Recommendation Report for Works to Tree(s) on trees subject to a Tree Preservation Order (TPO)

REF NO: AW/328/20/T

LOCATION: 7 Follett Close
Aldwick
PO21 4XH

PROPOSAL: T95, T96, T97 & T98 crown lift (removal/reduction of low branches) to achieve no more than 3metres overhead clearance on all aspects.
T95 & T98 only reduce top-height only to leave a minimum of 12metres above ground level.

TPO/AW/228/10

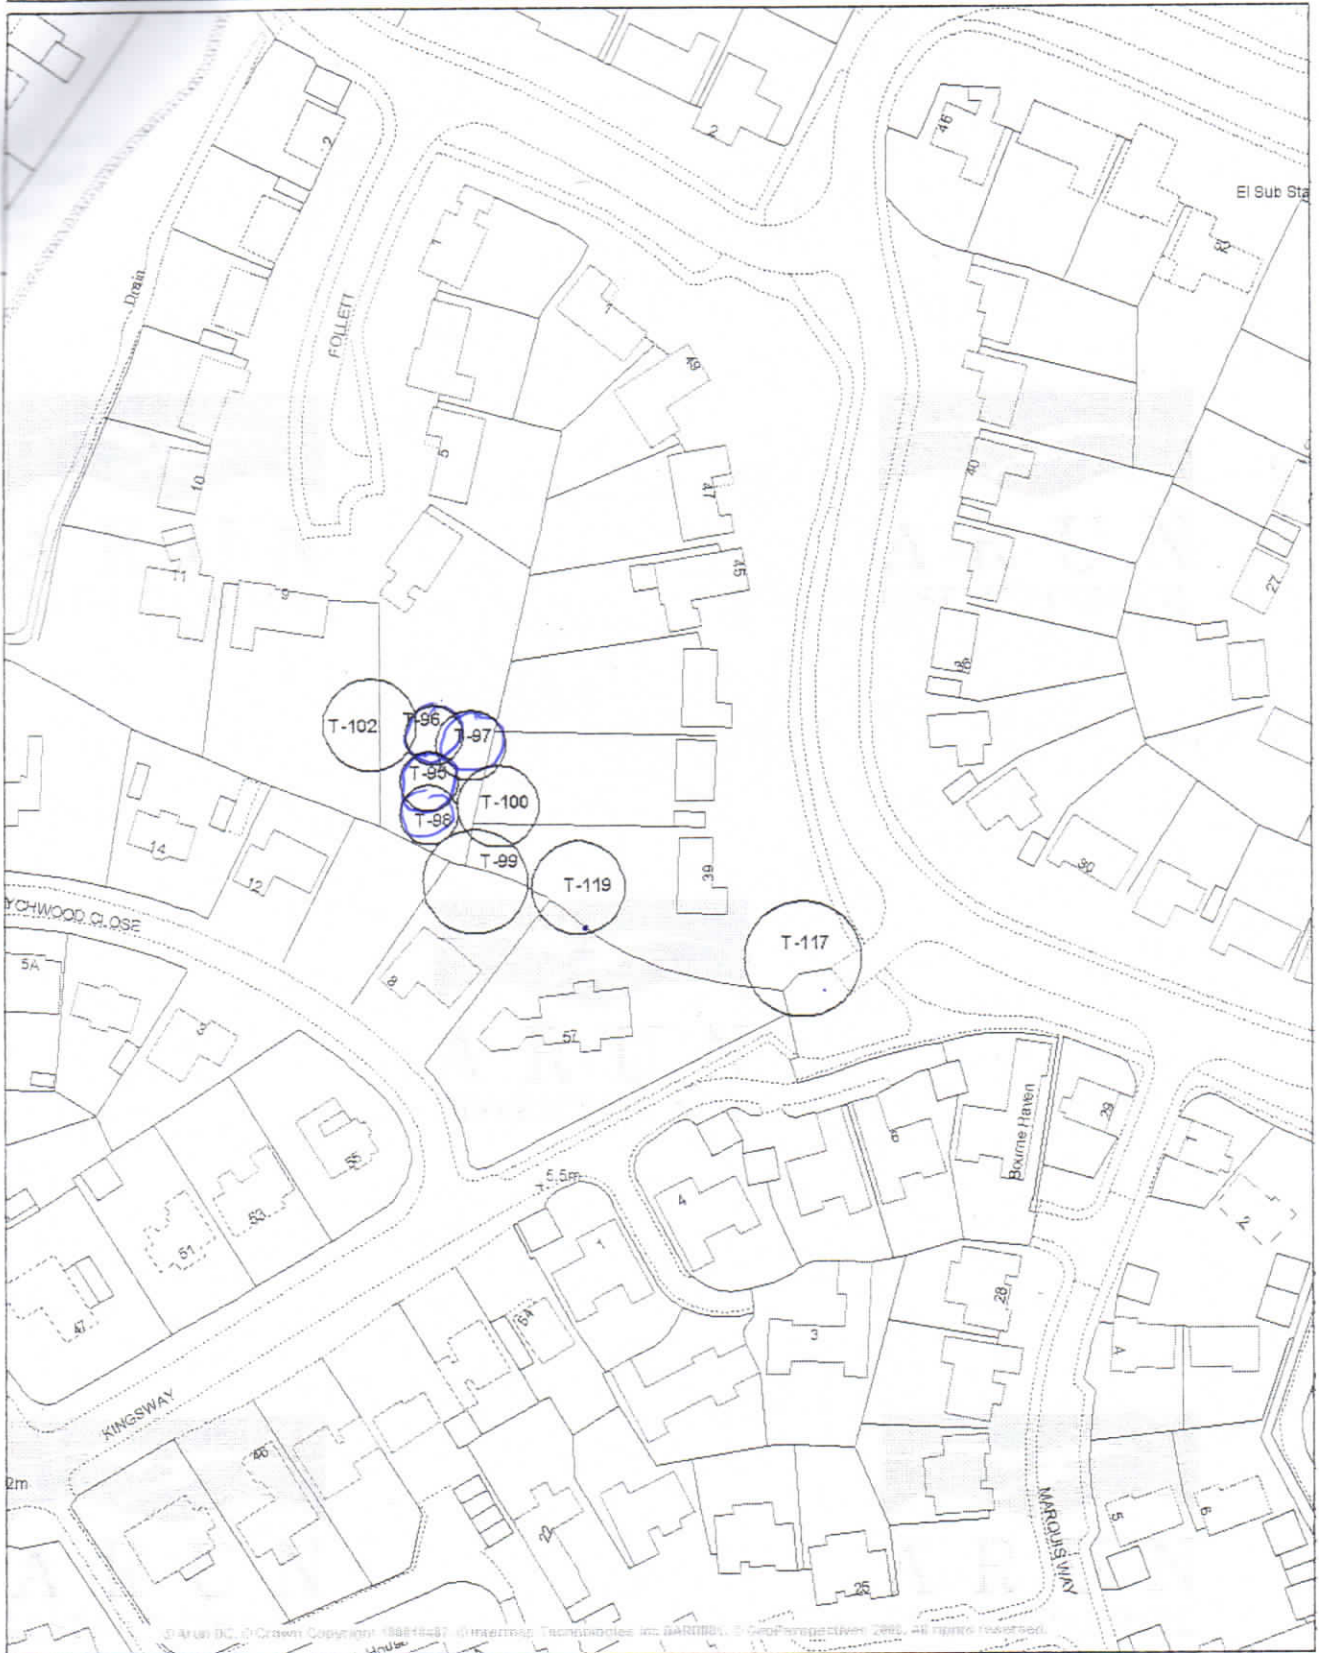
T97 is the northernmost birch, approximately 16m height with a uniform and unmodified crown. It displays all the mature characteristics of the species and is a fine specimen tree. T96 is also a single-stemmed tree with fine form and slightly apart from the group although less so than T97.

T95 and T98 are similarly unmodified and important constituents of the group although they are of lesser form and markedly inferior.

The extent of height reduction proposed is not possible to interpret given the disparity with my own estimation of existing top-height.

Height reduction proposals cannot be properly interpreted from the measurements provided. That said, I would be comfortable with some reduction pruning on T95 & T98 and I make suggestions for a revision of the work proposal below.

The removal of low branches to achieve 4m clearance above ground level is not justified on arboricultural grounds and exceeds that which is recommended in the British Standard (BS3998:2010) Tree work - Recommendations. Lesser works would be suitable, and I make suggestions for a revision of the work proposal below.

T95, T96, T97 & T98

Crown lift (removal/reduction of low branches) to achieve no more than 3metres overhead clearance on all aspects.

T95 & T98 only

Reduce top-height only to leave a minimum of 12metres above ground level.
